PLANNING CONSULTATION RESPONSE

Application No	2026/0108
Proposal	Erection of 4 padel courts with a covering structure, installation of a football pitch and erection of a new associated building to include changing facilities and cafe/social areas.
Address	Burntwood Sports and Leisure Centre, Common Road, Brierley, Barnsley S72 9ET
Date of Consultation Reply	09/04/2026
Consultee	Highways Development Control

KEY LEGEND

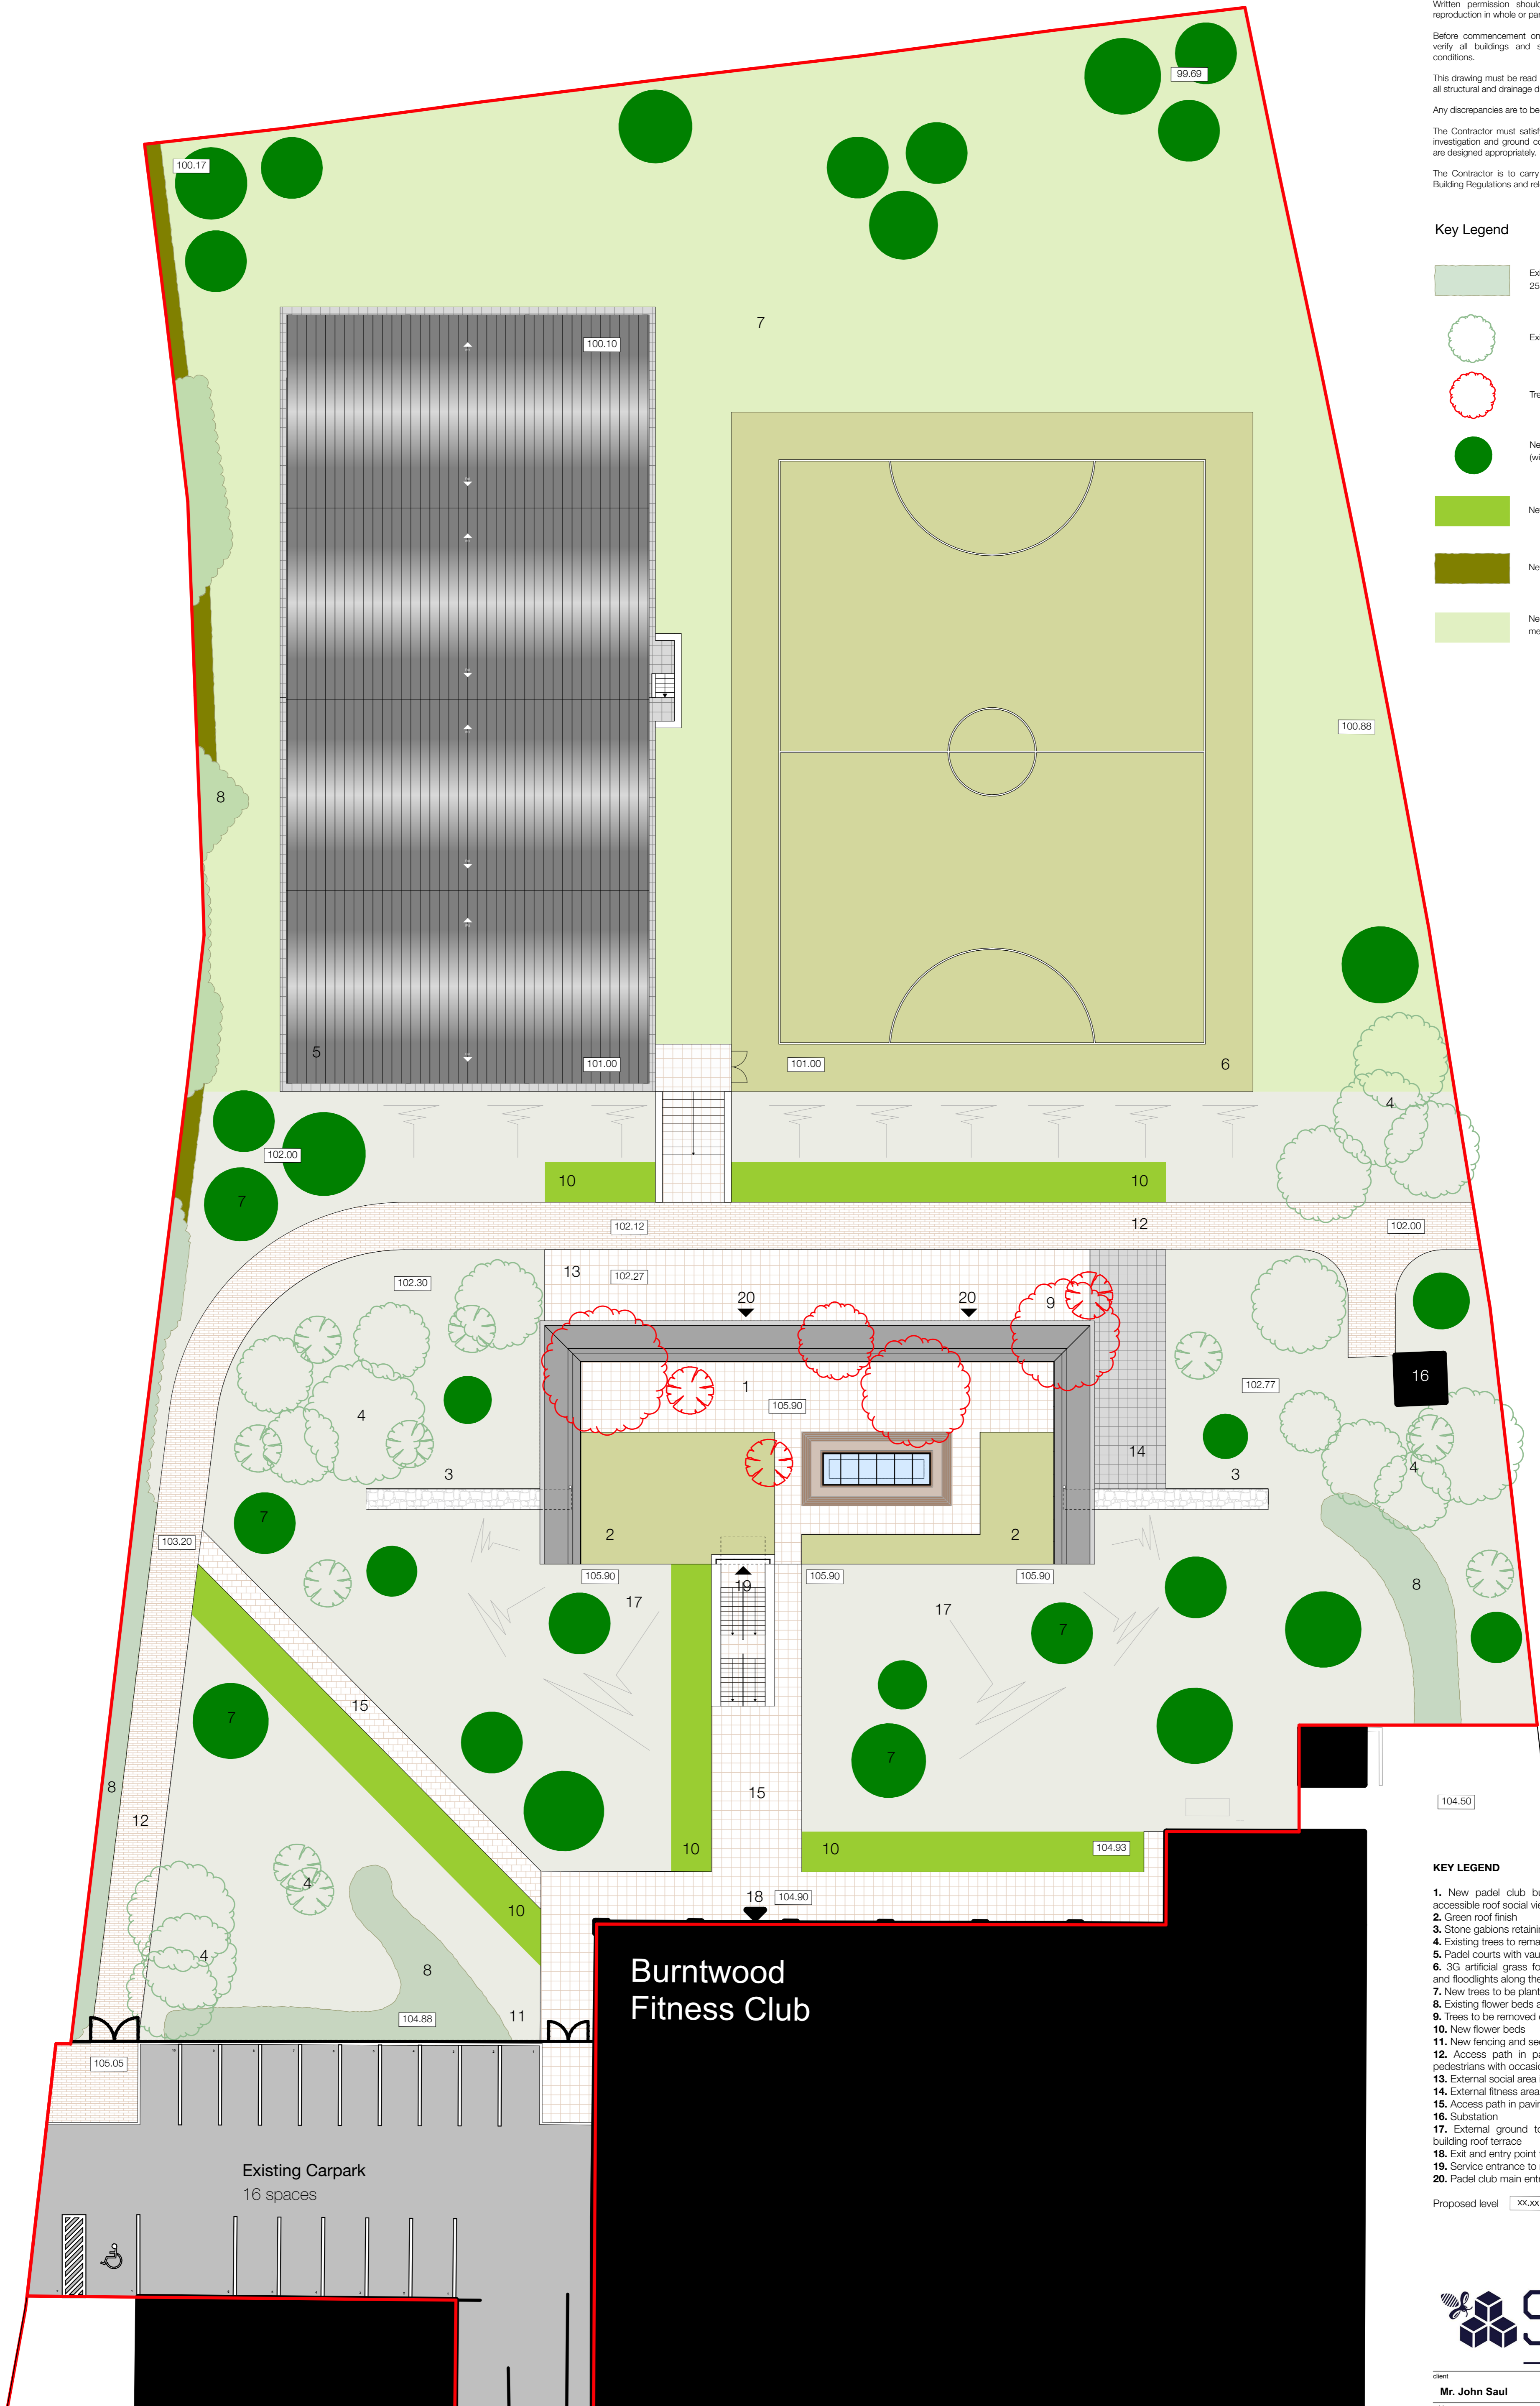
In terms of the site layout, the car park layout (16 spaces) shows the single blue badge holder space at the southwestern end of the car park. This is the furthest distance from the new Club house building and adjacent existing fitness club building, as well as being away from the natural desire line to and from access path (15) and fully accessible roof viewing terrace (1). In accordance with DfT Inclusive mobility document, *“Accessible parking spaces and drop-off points should be located as close as possible to building entrances, where safe access can be provided”*. As such it is requested that the layout is amended to reflect this.

In addition, the site layout plan (Item 12 in the Key Legend) identifies an *“Access path in paving or resin-bound gravel, for pedestrians with occasional access to substation, type A”*, served by gated access from the 16-space car park. While this route scales at approximately 3 metres in width and includes a turning head adjacent to the substation, it is presumed that this access may also be intended for use by emergency service vehicles. Accordingly, clarification is required—together with any necessary amendments or additional provision, as to whether this route is intended to function as a vehicle access in accordance with the requirements of Building Regulations Approved Document B (Fire Safety), Table 15.2 (extract provided below).

Should this route need to be designed in accordance with the details set out in Table 15.2, an amendment to the site layout will be required.
